MEMORANDUM

TO: Barbara Barhydt
FROM: Dan Goyette, P.E. & Ashley Auger, E.I.T.
DATE: August 13, 2010
RE: Poulin Property Holdings, LLC – Building Addition at 171 Warren Avenue

- Development Review Application, and attachments dated August 3, 2010, submitted by Poulin Property Holdings, LLC, and Northeast Civil Solutions.
- Engineering Plans, Sheets 1, 2, 3, dated July 26 and July 27, 2010, and sheets A1, A2, A3, dated July 22, 2010, prepared by Northeast Civil Solutions on behalf of Poulin Property Holdings, LLC.

SITE PLAN

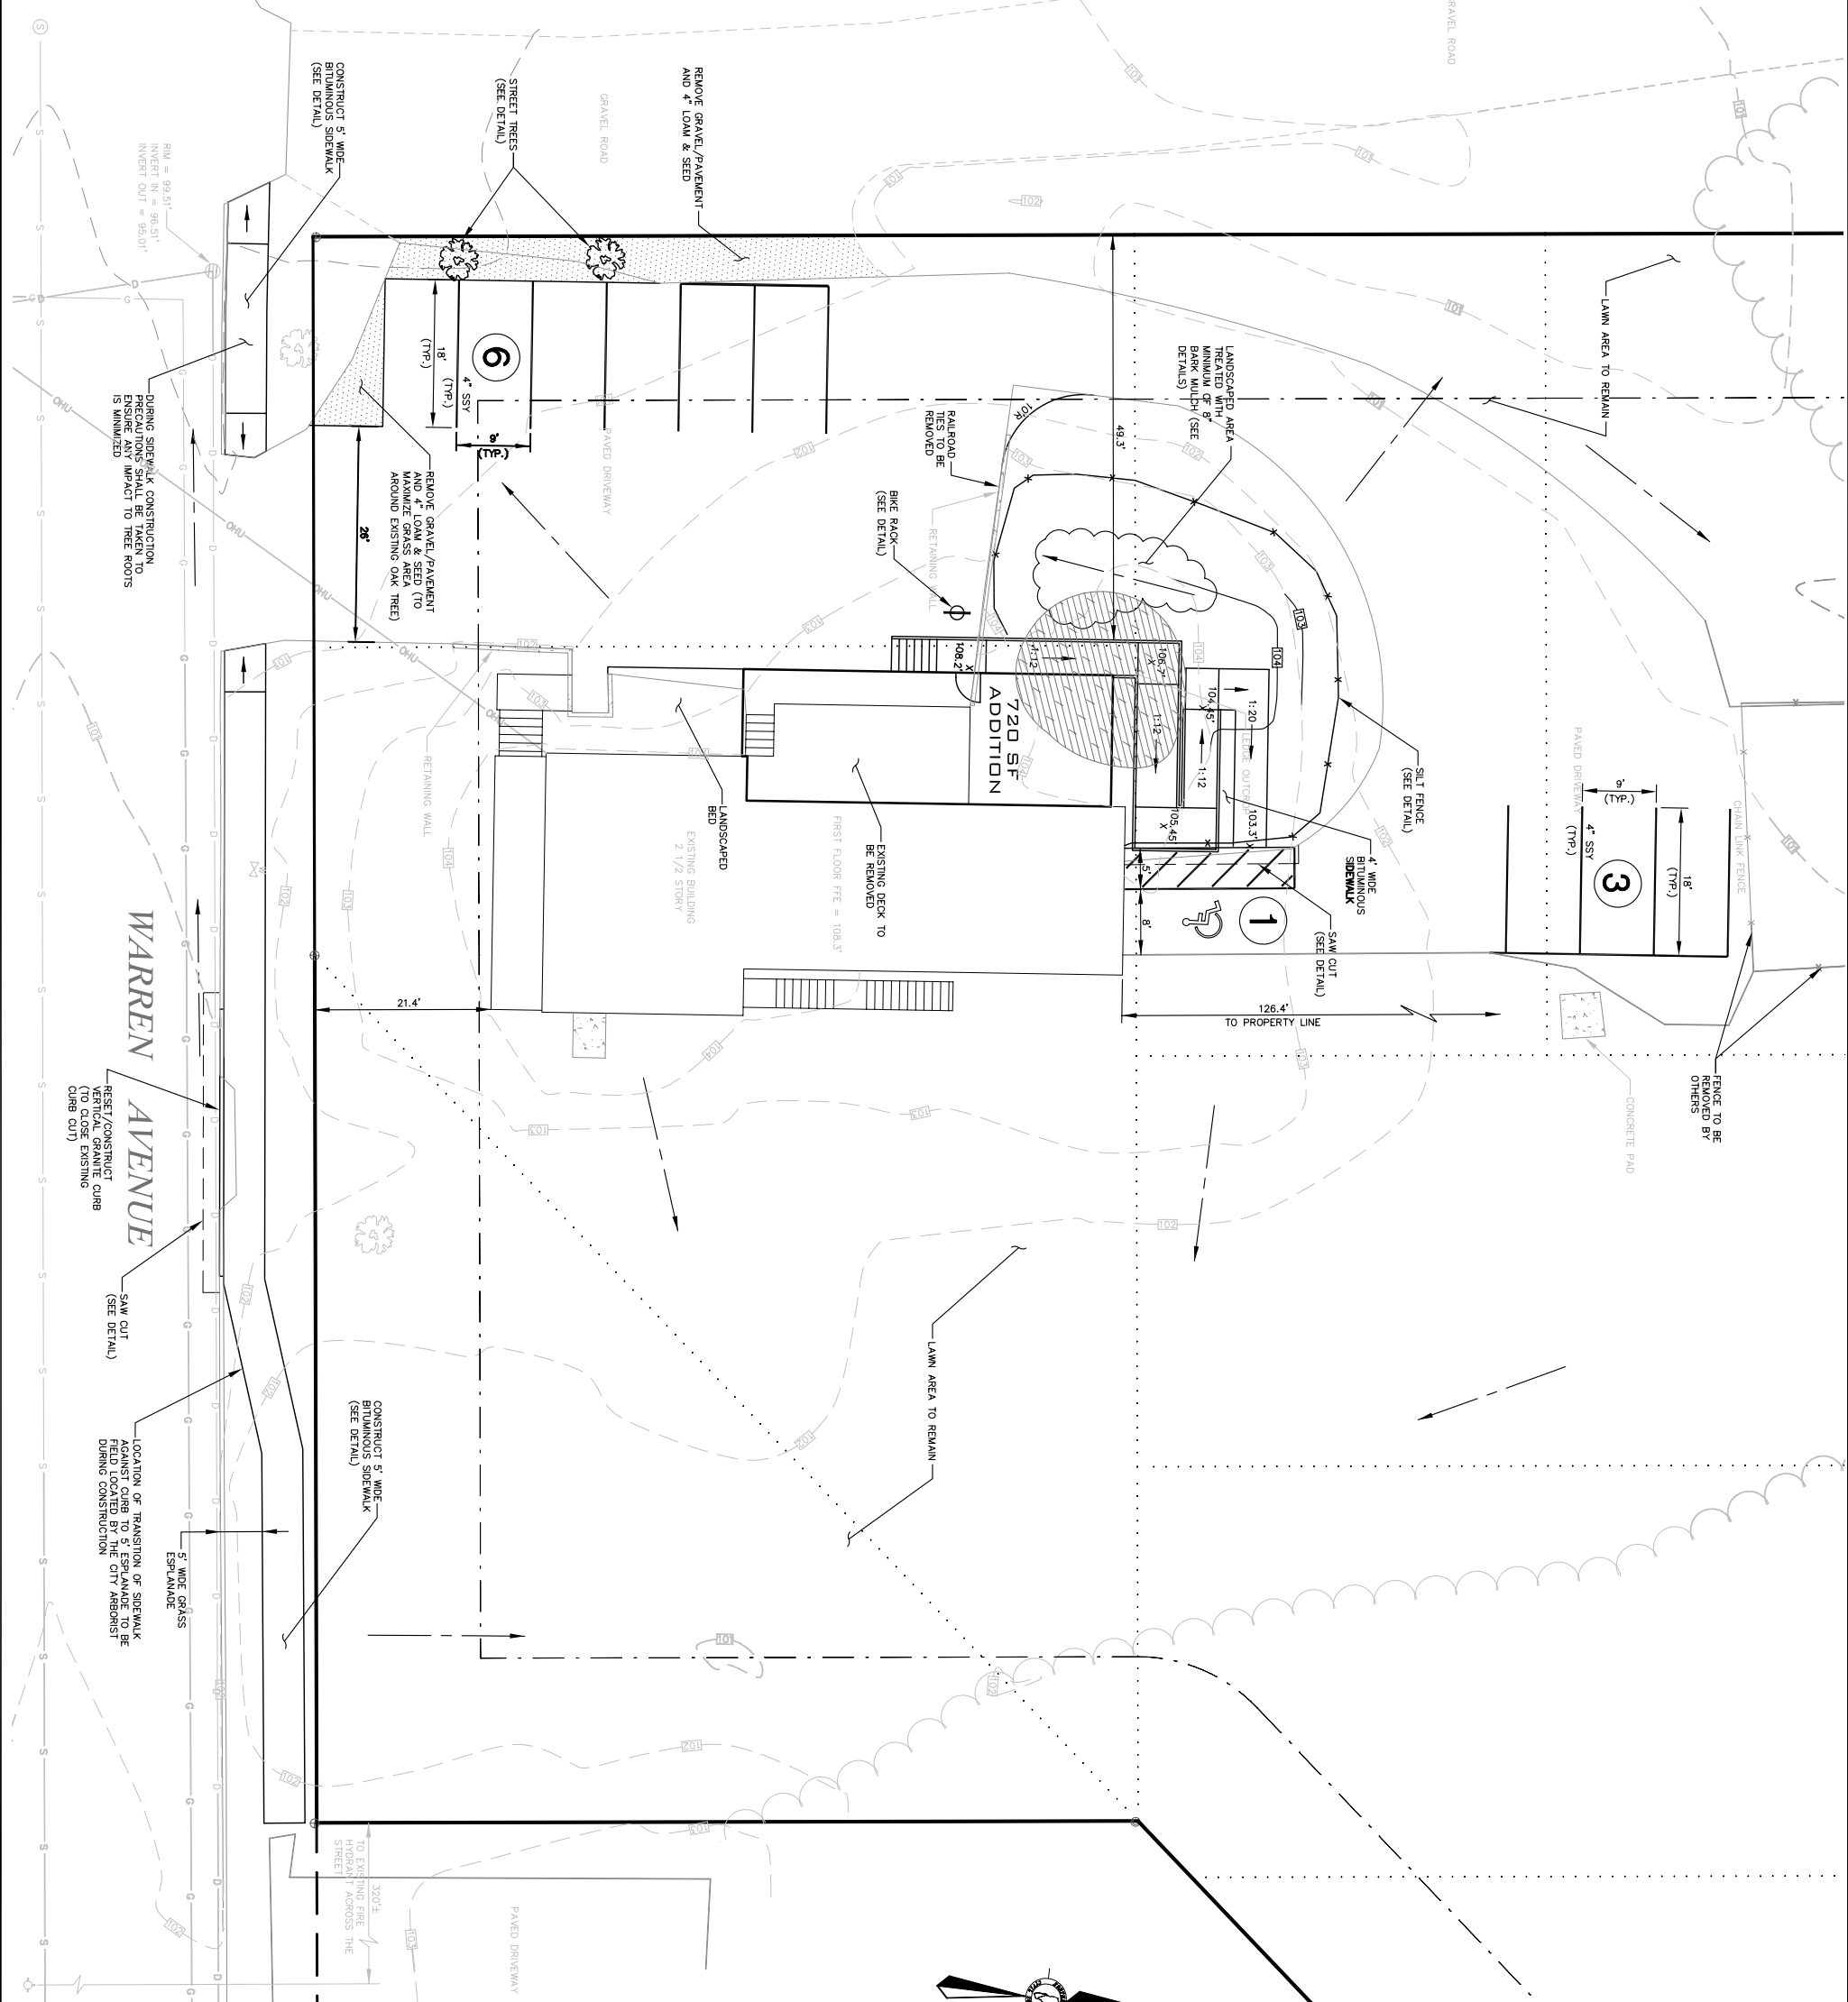
- The 720 square foot office addition, the 278 square foot paved walkway, and the 316 square feet of planting area result in a proposed impervious area net change of 682 square feet. A proposed impervious area net change of 644 square feet was reported; this needs to be clarified.
- Sheet A1 of the Engineering Plans is not printed to the scale specified on the drawing.
- A detail has not been provided for a cross-section of the proposed bituminous sidewalk.
